July 24, 2018

Re: MMC Staff Parking Garage | 222 St. John Street | Level III Site Plan
Response to Public Comments

Thank you for coordinating the review of the Maine Medical Center Parking Garage project located at 222 St. John Street. This letter provides a summation of our responses to the comments received from various reviewers as part of the Level III Site Plan process. We have repeated the original comment in italics below, and our response follows each.

TYPICAL HYDRANT ASSEMBLY DETAIL
N.T.S.

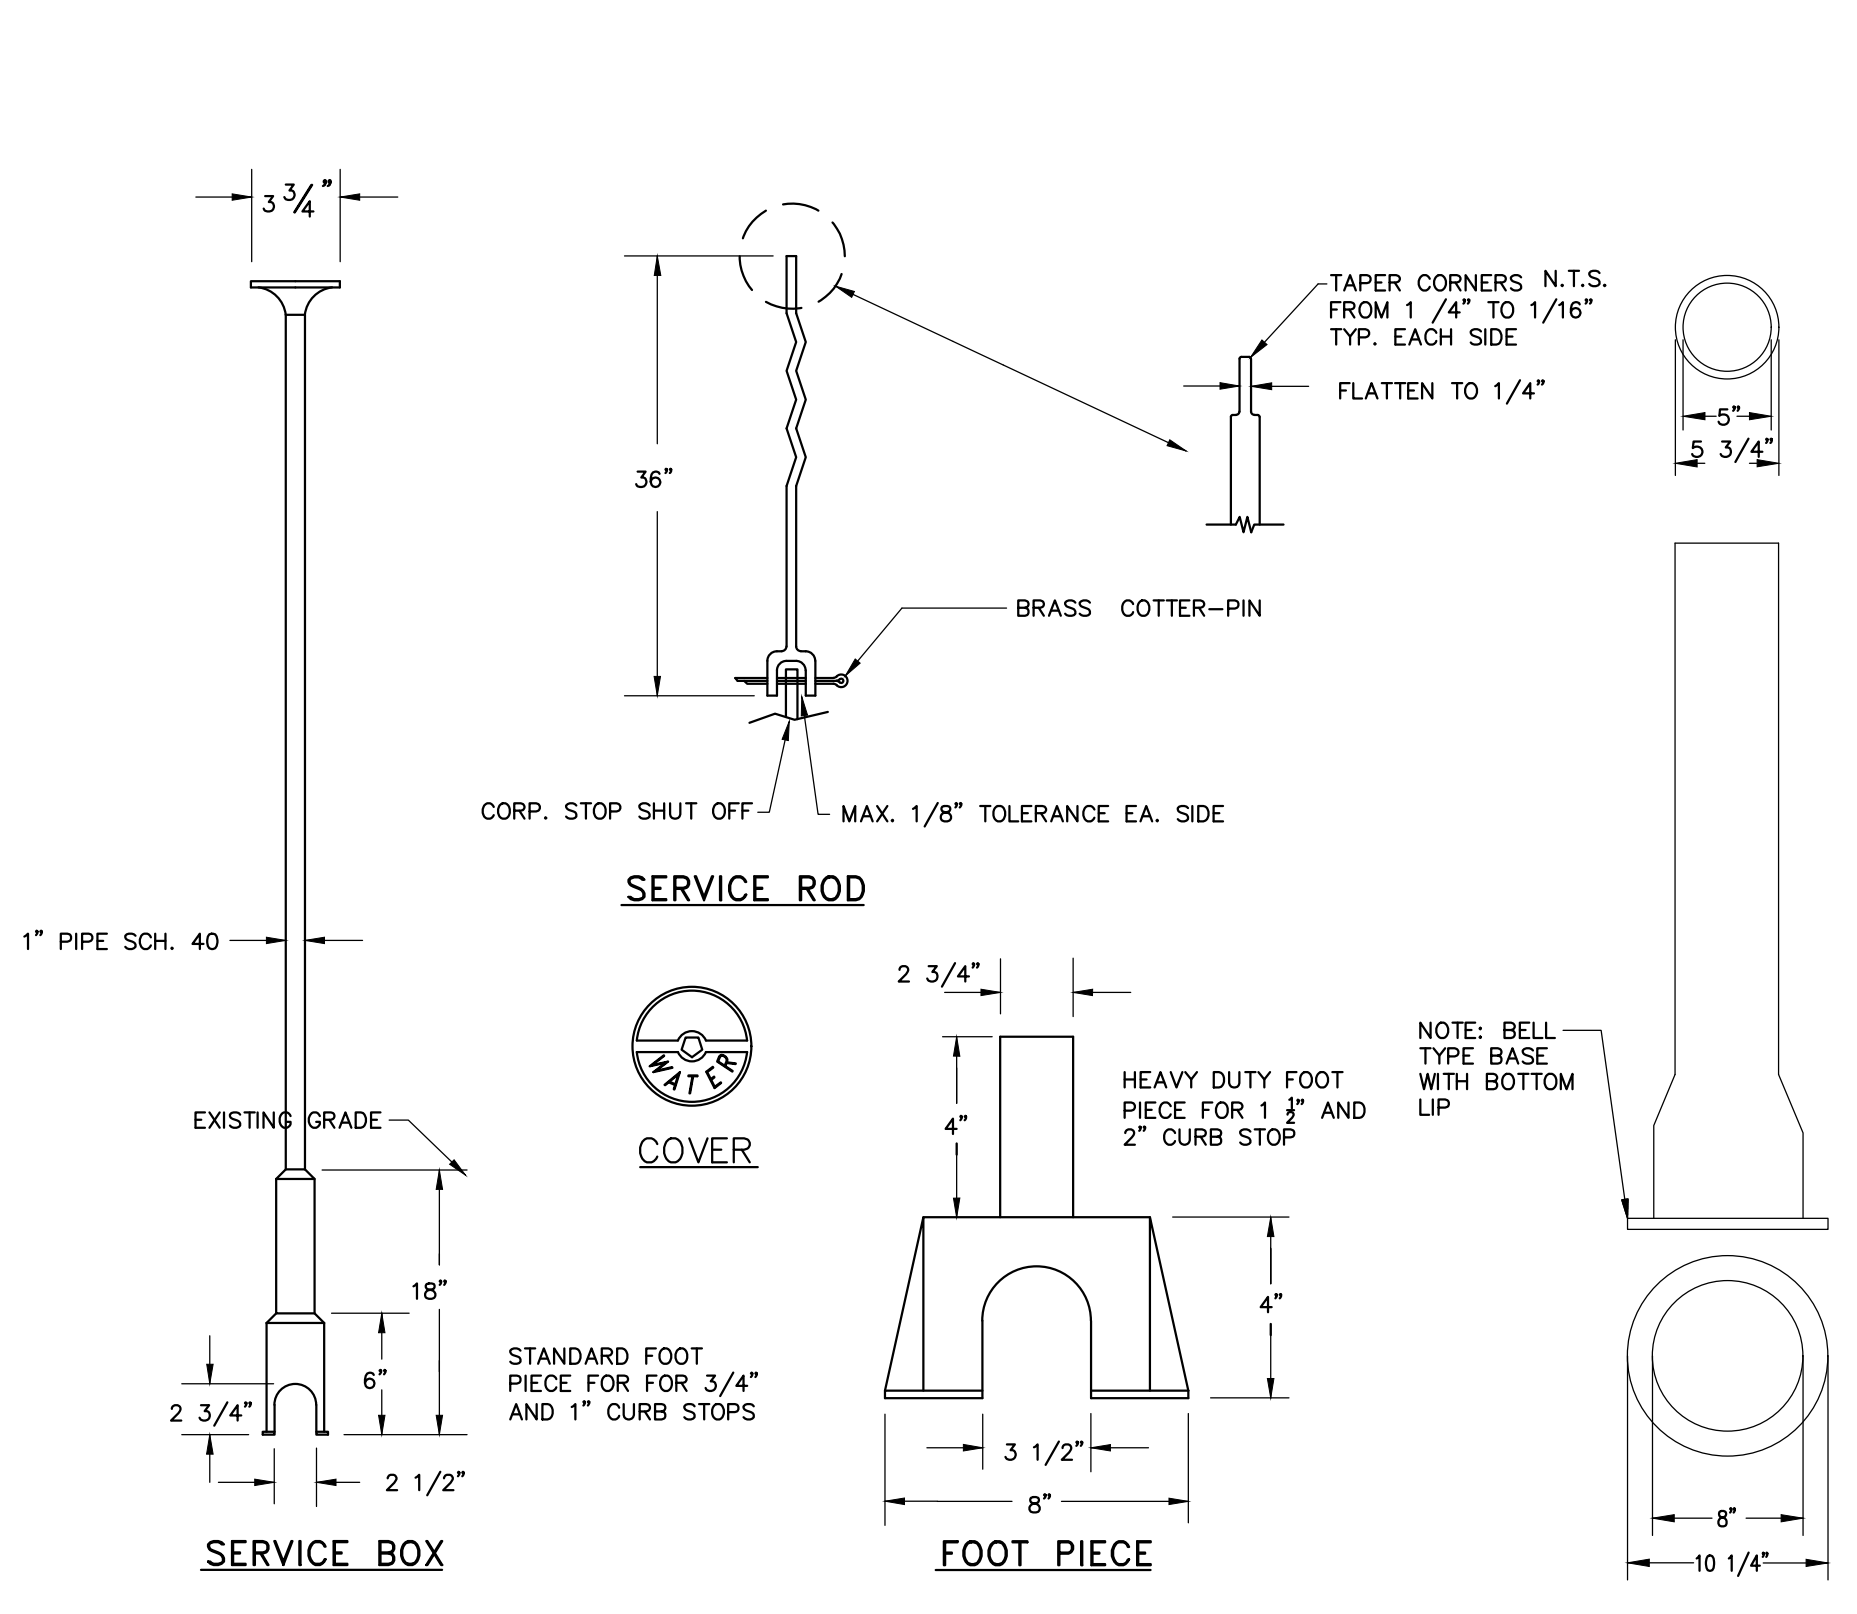
2. *A private fire hydrant will be required along the right side of the building, accessible from the lower parking lot.*

Response: A private hydrant has been proposed adjacent to the garage entrance accessible from the lower parking lot. Please refer to the attached revised design drawings for the updated hydrant location.

GRADING & DRAINAGE PLAN - 2

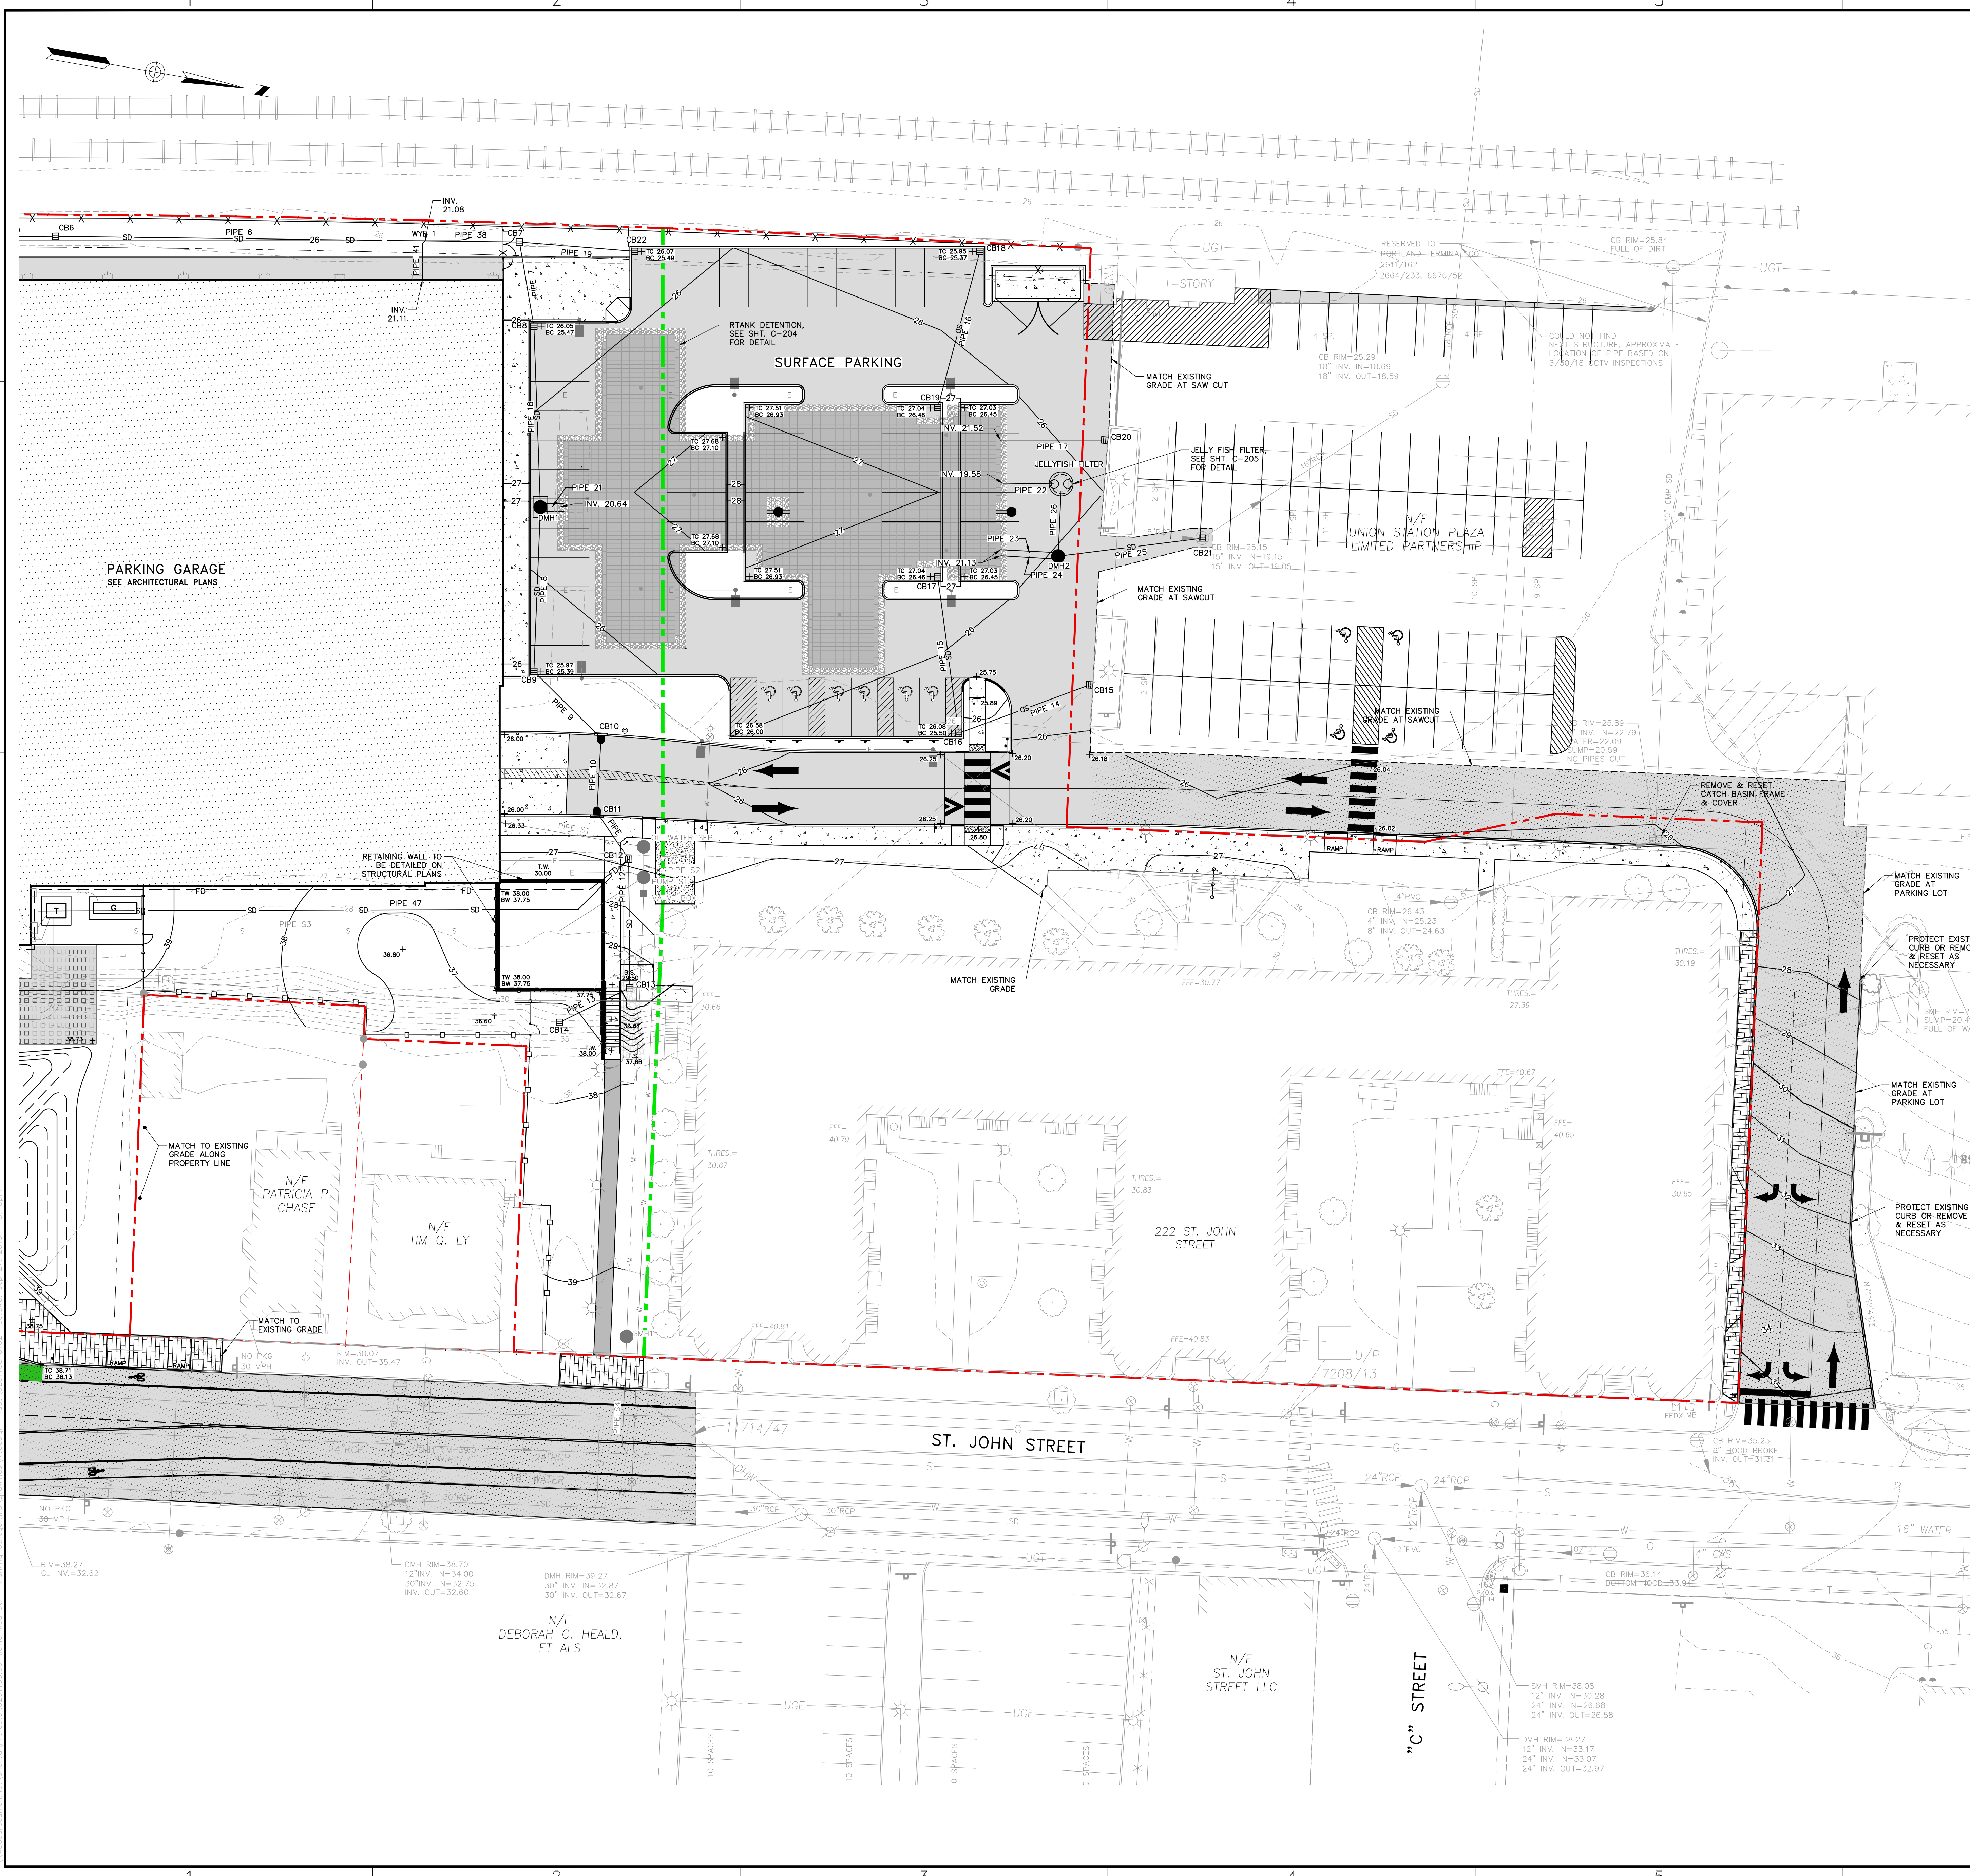
c. *CB21 on sheet C-103 calls out a 15" pipe out of the structure, but the existing pipe between CB21 and the existing CB is referenced as 18". Please confirm the existing pipe is indeed an 18" pipe.*

Response: The correct pipe size has been updated, please refer to the attached revised design drawings for additional clarification.
